**EL PASO COUNTY PLANNING AND
 COMMUNITY DEVELOPMENT
 DEPARTMENT**

STORMWATER MANAGEMENT PLAN CHECKLIST

Revised: July 2019

PHASING PLAN (PHASE 1)

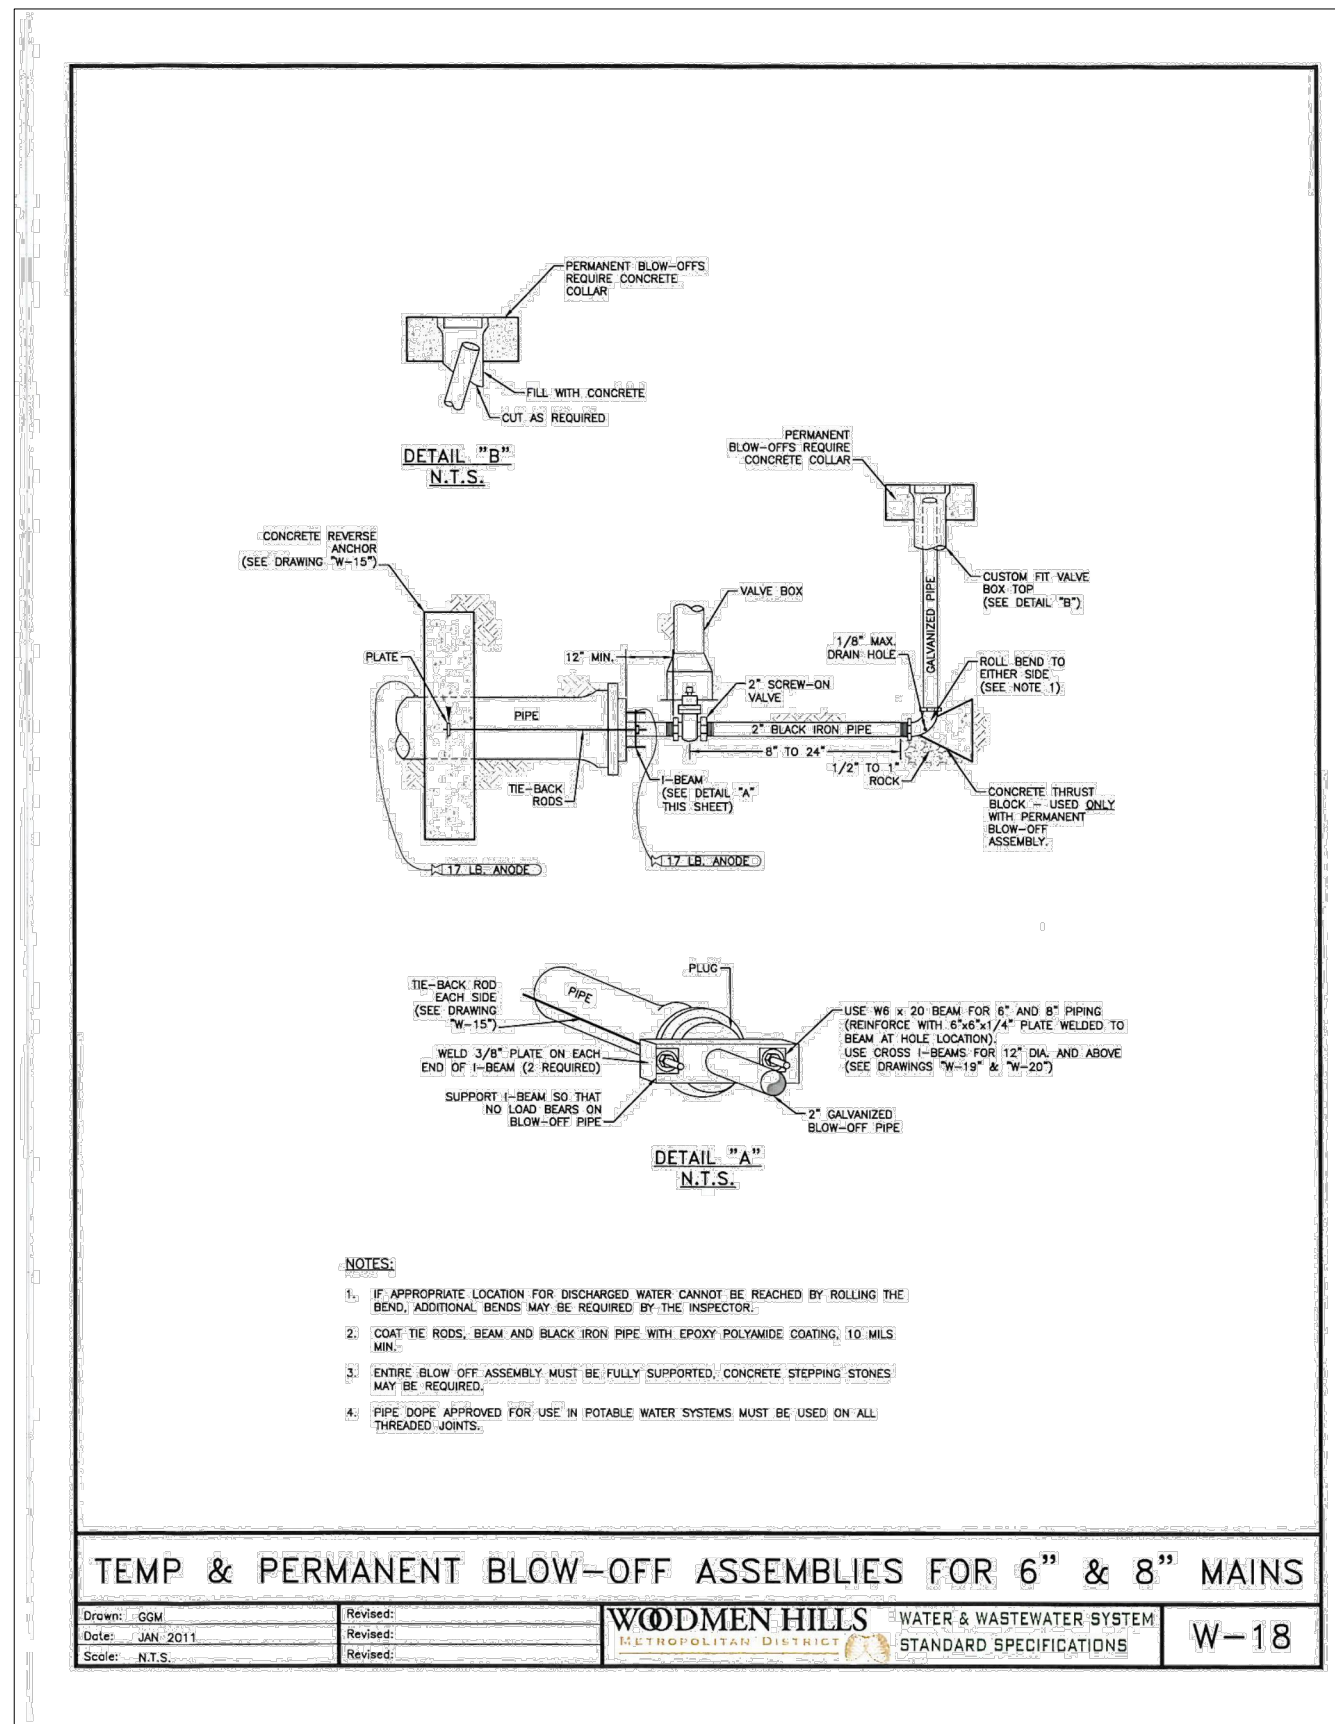
| | | Applicant | PCD |
|--|--|-----------|-----|
| 5 | Phasing plan – may require separate drawings indicating initial, interim, and final site phases for larger projects. Provide “living maps” that can be revised in the field as conditions dictate. | N/A | X |
| <p>NO PHASING PROPOSED. EARLY GRADING GRADING & EROSION CONTROL PLANS</p> <p>Old comment? PUDSP is not an EGP. Phasing plan already included in SWMP. Add more detail to that section.</p> | | | |
